Application No: AW/98/20/PL
Site Address: 1 Avisford Terrace, Dillons Newsagents Rose Green Road Aldwick PO21 3HB
Description of works: Construction of a single storey office extension to the rear of the property, including the removal of the existing store room. Works will also include the replacement of the existing shop front and dwarf walls with fully glazed aluminium windows and doors. Retail area to be used as showroom.

OWPC26883

NOTES:	
PROPOSED EXTENSION & NEW SHOP FRONT AT 1 AVISFORD TERRACE	
PROPOSED FLOOR PLAN & BOUNDARIES	
Britannia Windows 1 Avisford Terrace Rose Green Road Bognor Regis PO21 3HB	
Contract No:	
Drawn by: PDS	
Surveyed by: PDS	
Scale: 1:75 @A3	Date: 15/04/2020
Drawing No: 07.A

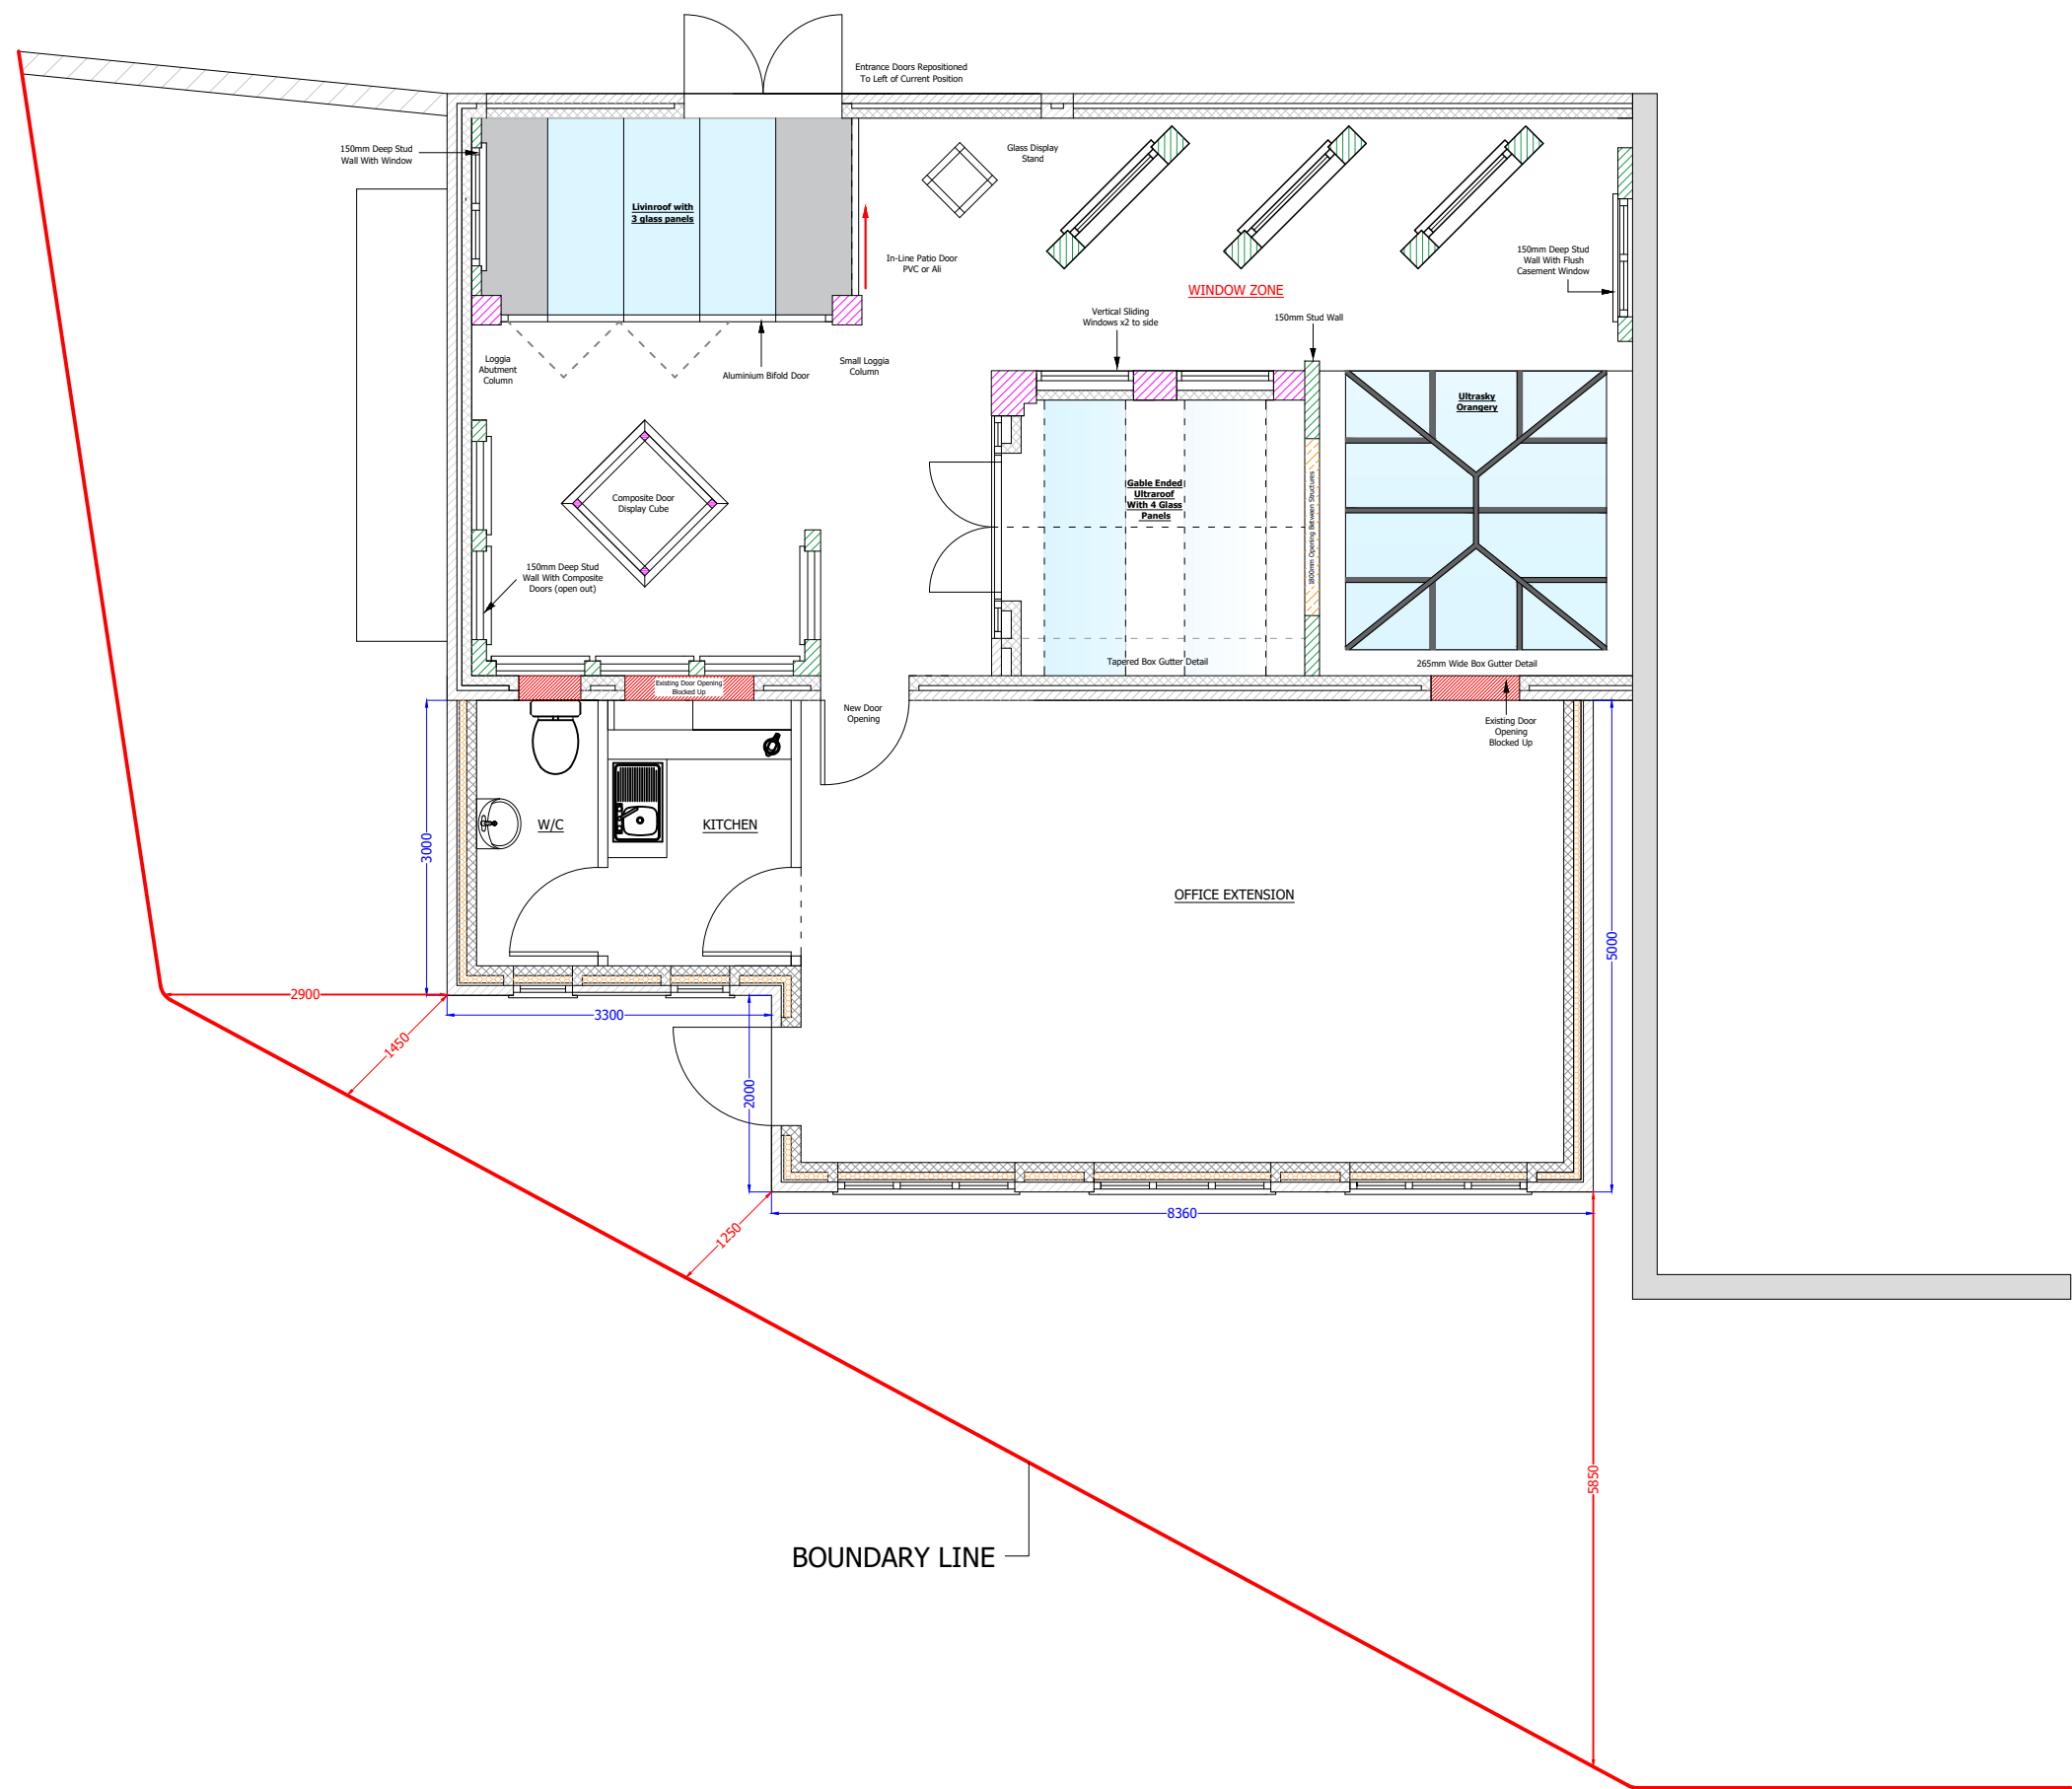
Members had no objection to the application, however they considered that, were the application approved, a condition should be included requiring the doors to open inwards and not outwards and that cycling racks be provided in line with TSP 1d of the Arun Supplementary Design Guide.
